Objection to State Significant Development Application SSD-89869959

10 Dangar Street, Wickham NSW 2293 — Concurrent Rezoning and 43-Storey Mixed-Use Development

Application: SSD-89869959 — demolition and construction of a 43-storey mixed-use tower (245 apartments including 42 affordable dwellings, 99 co-living rooms, 171 hotel rooms, retail, function and recreation uses, basement parking), together with a concurrent amendment to the Newcastle Local Environmental Plan.

Site: 10 Dangar Street, Wickham NSW 2293

Basement 03

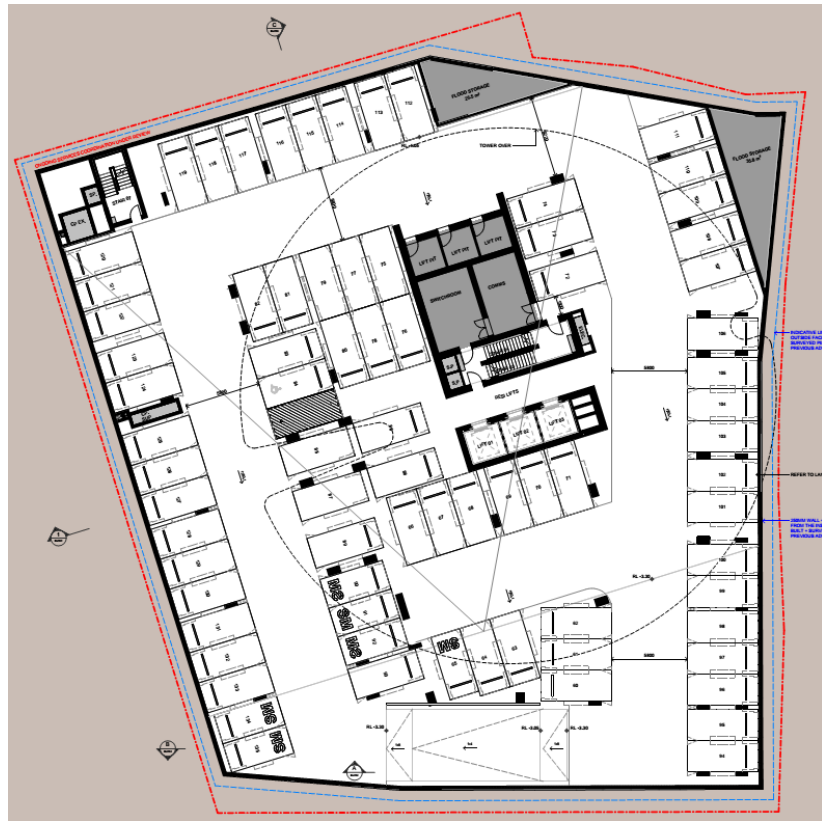
- **Appendix XX (Fire Engineering)** confirms **12 performance-based departures**, including extended travel distances (up to 12m to a point of choice vs 6m prescribed; basement 30m/60m), **exits less than 9m apart on Basement 03 and Level 42**, public corridors up to **55m** without smoke-proof subdivision, and a hydrant serving a building over 135m effective height — and warns "additional fire engineering issues may be identified."

Level 42

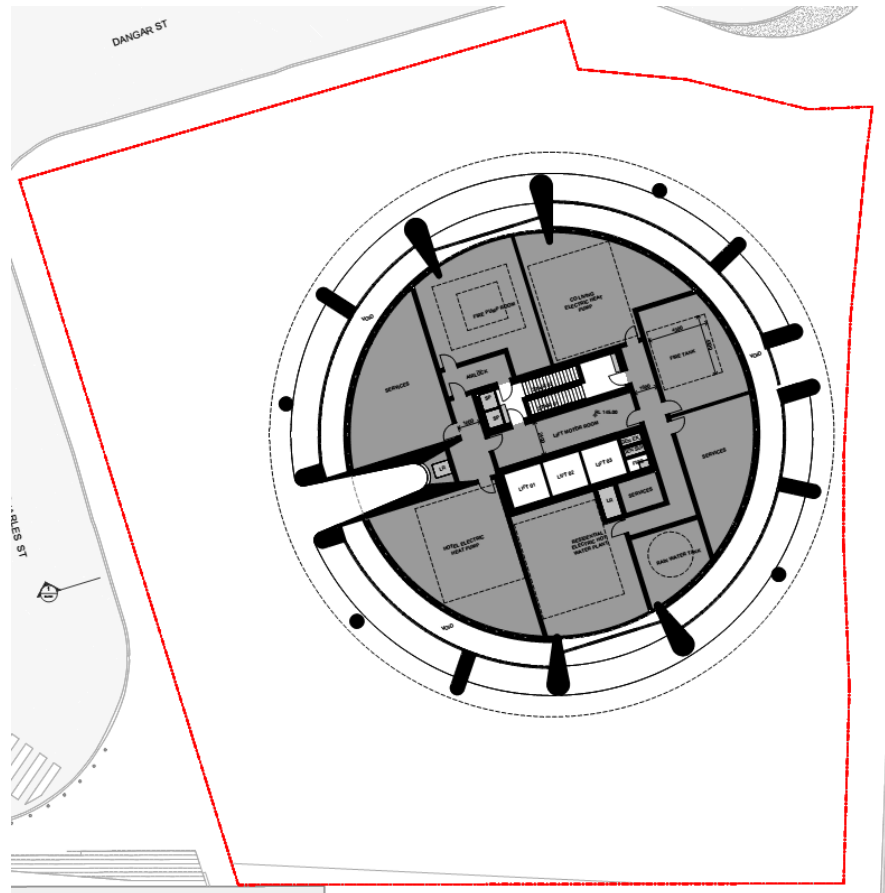
This is a life-safety matter, not an amenity quibble. The pedestrian wind study (Appendix P, RWDI) found that tested Level 42 balcony locations **failed the annual wind safety**

criterion (threshold 83 km/h) in both the proposed and future configurations. Tested results include:

- Sensor 88: **104 km/h** proposed / **105 km/h** future
- Sensor 90: **106 km/h**
- Sensor 91: **115 km/h** proposed / **116 km/h** future

These are exceedances of more than **30% above the safety threshold**, in private trafficable balcony areas. Rather than re-test a mitigated design, RWDI reviewed updated drawings received on 30 March 2026 and issued its final "no further wind mitigations are required" conclusion on **31 March 2026 — one day later** — relying on awnings, impermeable partitions and **landscaping that was never modelled** and is subject to maintenance, maturity and storm damage. A Level 6 podium sensor also showed an uncomfortable result. Any exceedance of a safety criterion on a 43-storey residential tower should be treated as a design failure, not papered over. **Remedy: require RWDI or an independent wind engineer to re-test or certify the final design before determination; lock all mitigation geometry into the approved plans; require all trafficable areas to meet their intended-use comfort category; require a DCP wind-compliance table and a maintenance condition.**

# Ground Floor & Public Domain Plan

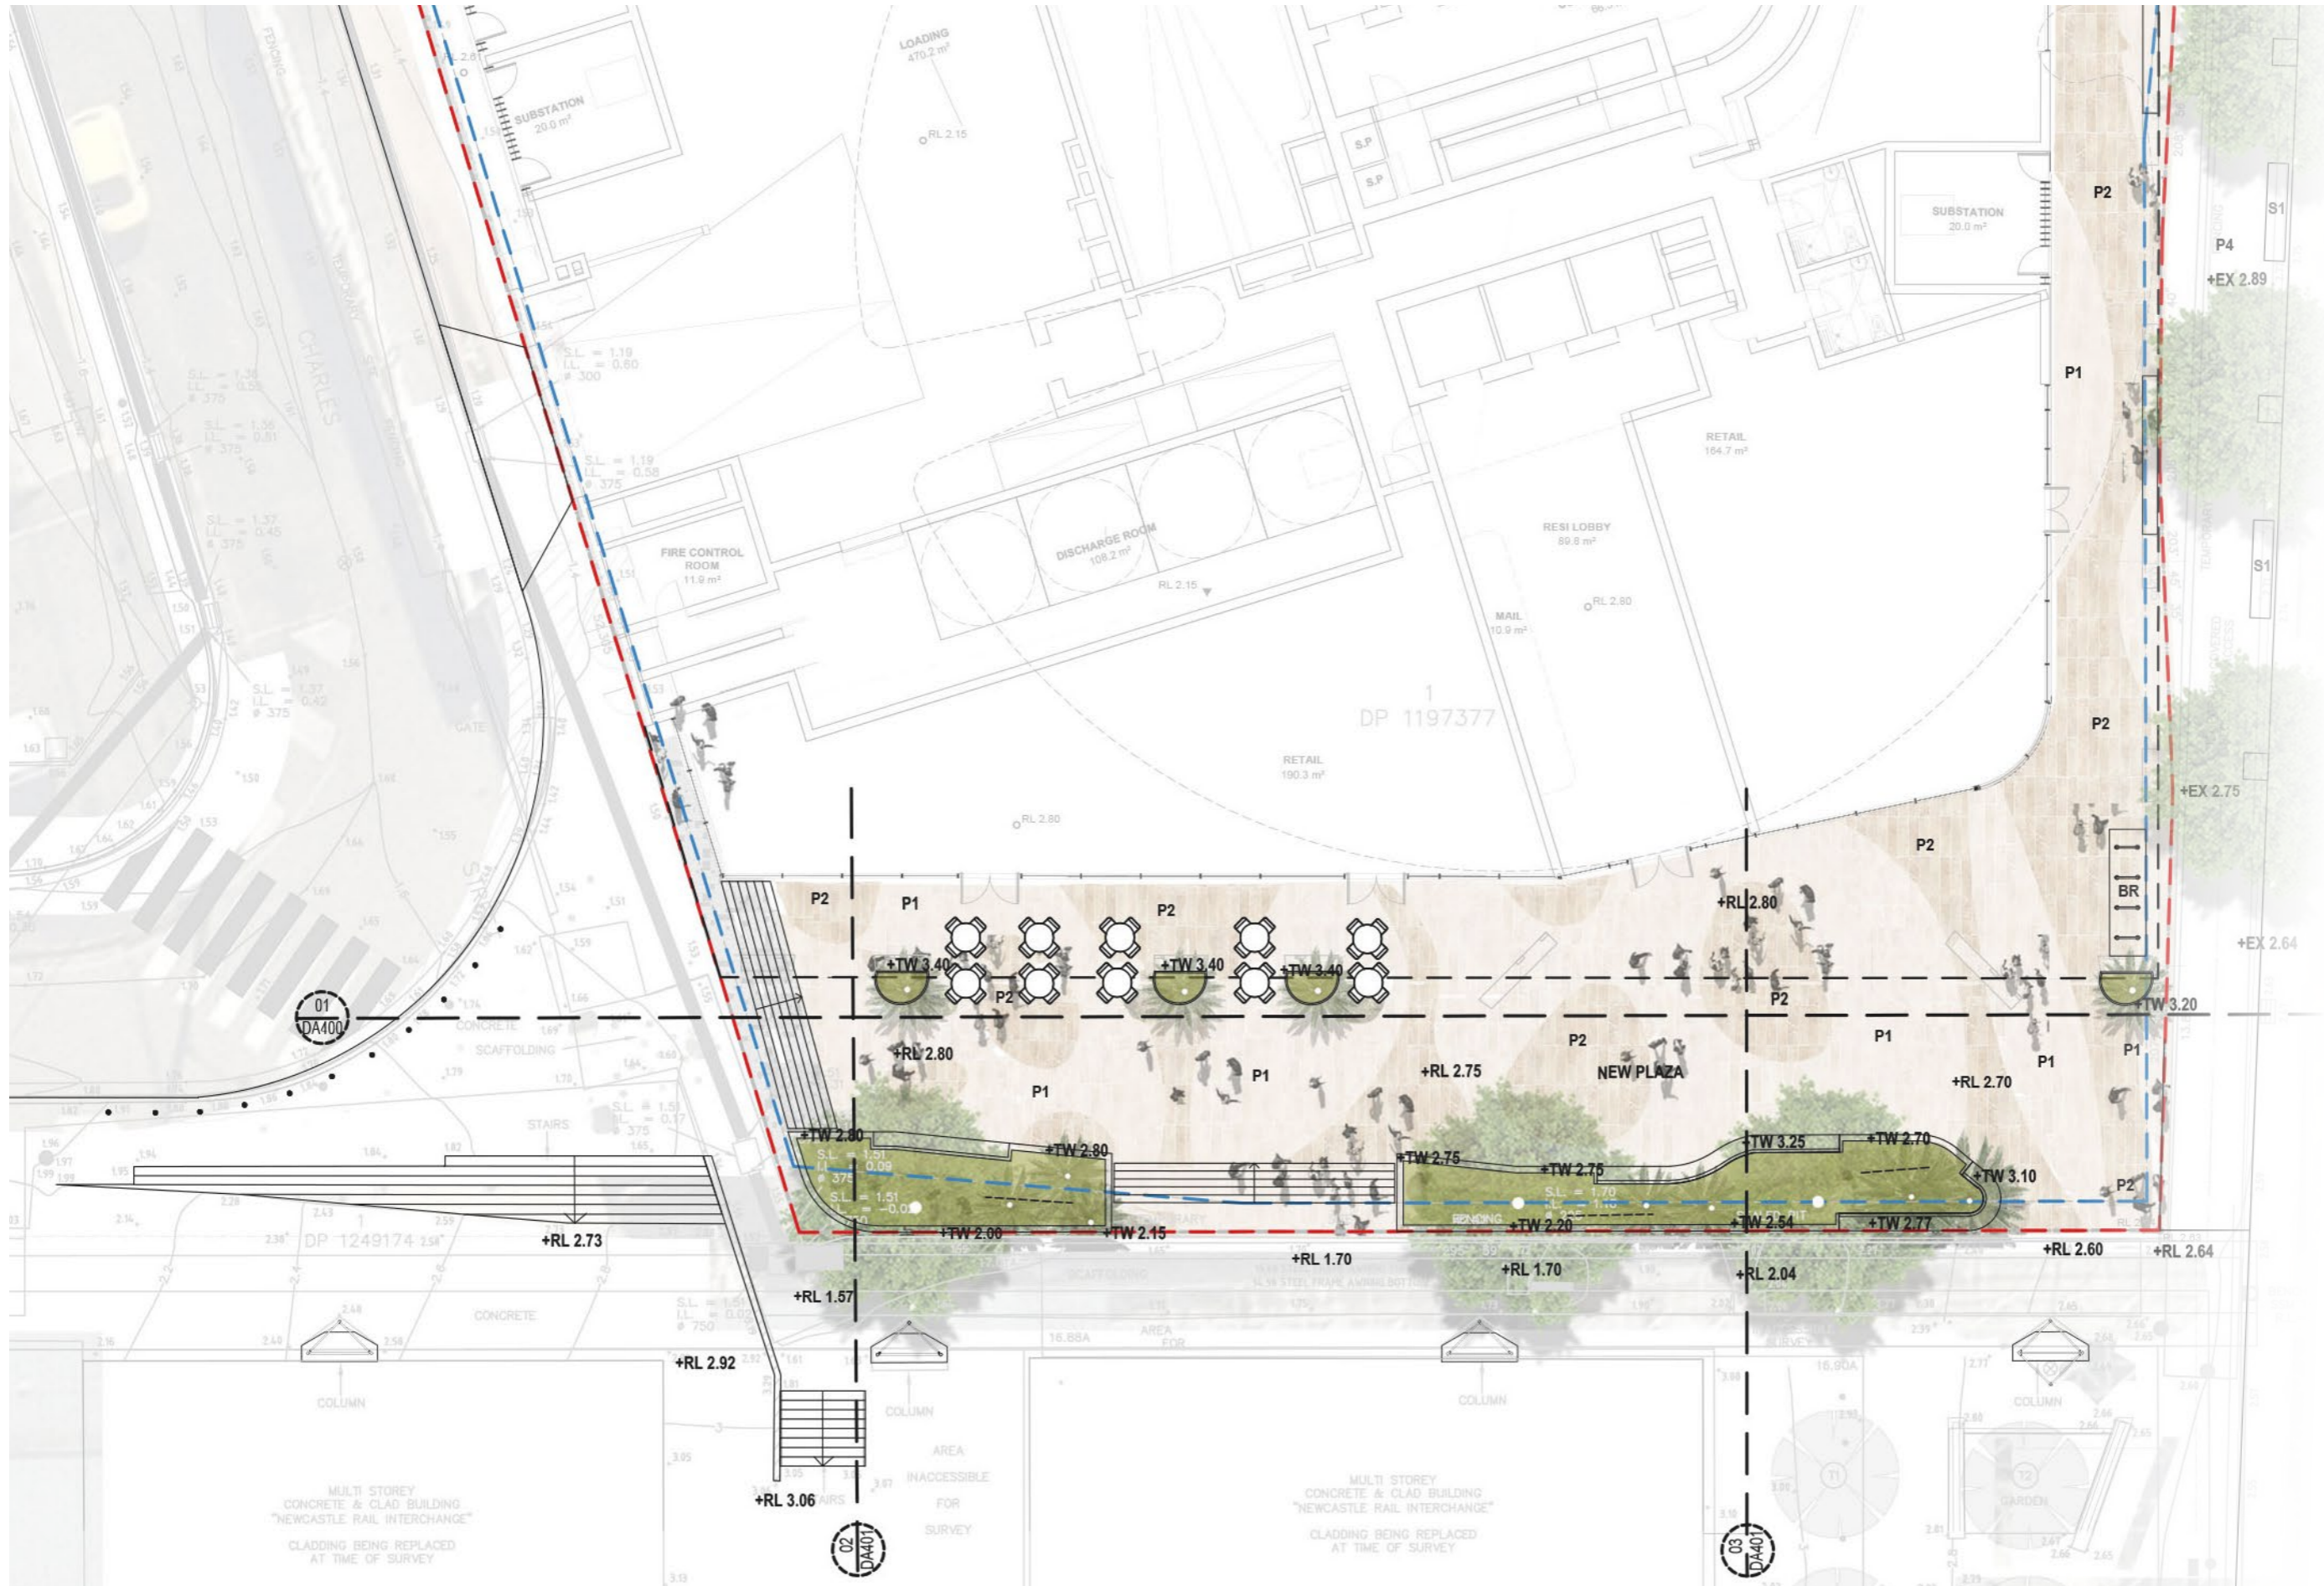
The urban design report (Appendix M, SJB) is a persuasive advocacy document by the project architect, not an independent justification. It relies on an 847m² public space / through-site link as civic benefit, secured only by a future easement, while Appendix J reveals an internal contradiction: the application says it "does not seek any changes to the public domain streetscape" yet relies on a Roads Act approval for kerb extensions, raised crossings, footpath, stormwater and traffic works that must be amended for this scheme. ADG compliance is asserted ("refer apartment plans," "noted and complies," "subject to design development"), deep soil is **zero**, and the metrics do not even reconcile across appendices (FSR stated as 14.3:1 in Appendix M vs 14.4:1 in the rezoning material; car-share and motorcycle figures conflict between Appendices M and S; typographical errors throughout, including "House Delivery Authority" and "Dapartment"). A development cannot disclaim public-domain change and simultaneously bank it as public benefit. **Remedy: Council/TfNSW-endorsed public-domain plans; a coordinated quantitative ADG compliance schedule; a single reconciled design-metrics table; public-domain delivery secured as pre-commencement or deferred-commencement conditions.**

Existing site photo - Honeysuckle Drive

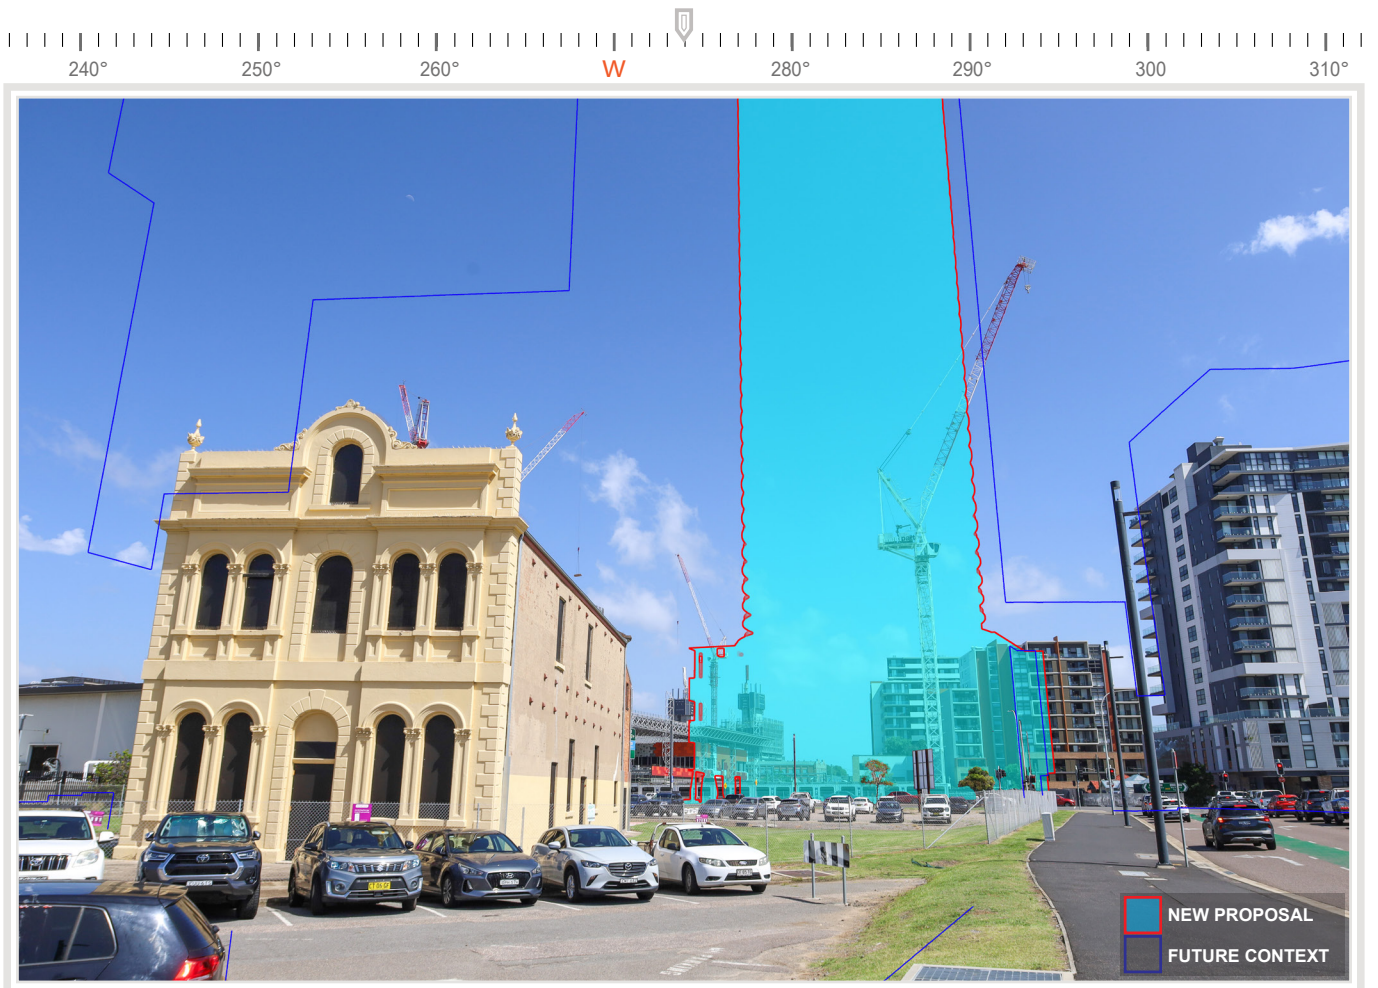
The applicant's own Visual Impact Assessment rates Viewpoint 04 (Honeysuckle Drive) as **Severe** and Viewpoints 05 and 10 as **Moderate-to-Severe**. The report then softens these impacts by assuming surrounding sites will be developed to a "maximum building height + 30%" future scenario — buildings that are **speculative, not existing or approved**. The heritage report concedes impact beyond a strict 100m catchment near multiple heritage items and a Heritage Conservation Area. A severe current impact remains a severe current impact; the Department must assess the actual proposal against the existing and approved context, not assume unbuilt towers will rescue it. **Remedy: independent peer review of the VIA; verified photomontages from low-rise streets, heritage items and public spaces; cumulative analysis on existing/approved context only; reduced height and massing.**
